Redevelopment of the Australian Technology Park (SSD 7317) - Notice of Exhibition

Thank you for your letter 11 January 2016 requesting Transport for NSW (TfNSW) comment on the above development application.

TAB A – Detailed Comments on the Transport Impact Assessment report

Figure 2.3: Cycle Network

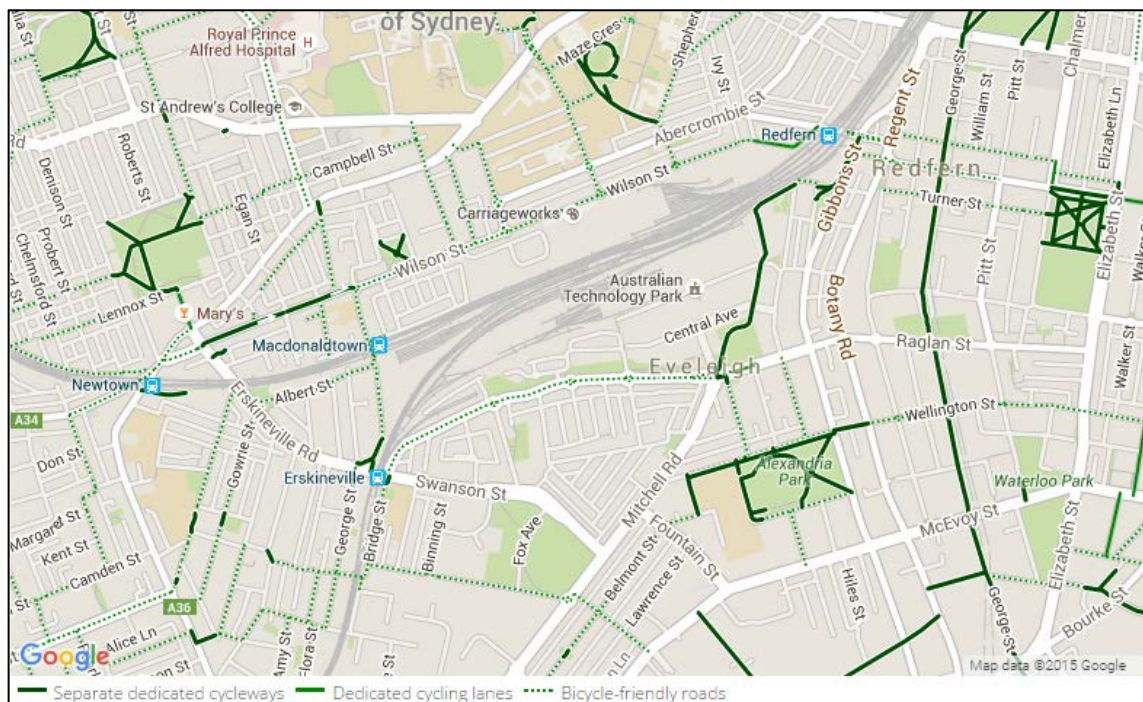
- Figure 2.3 of Transport Impact Assessment provides peak hour turning volumes. However, no information is provided in relation to peak hour period;
- It is not clear from the Transport Impact Assessment how traffic generation figures have been estimated based on the results of the parking occupancy surveys;
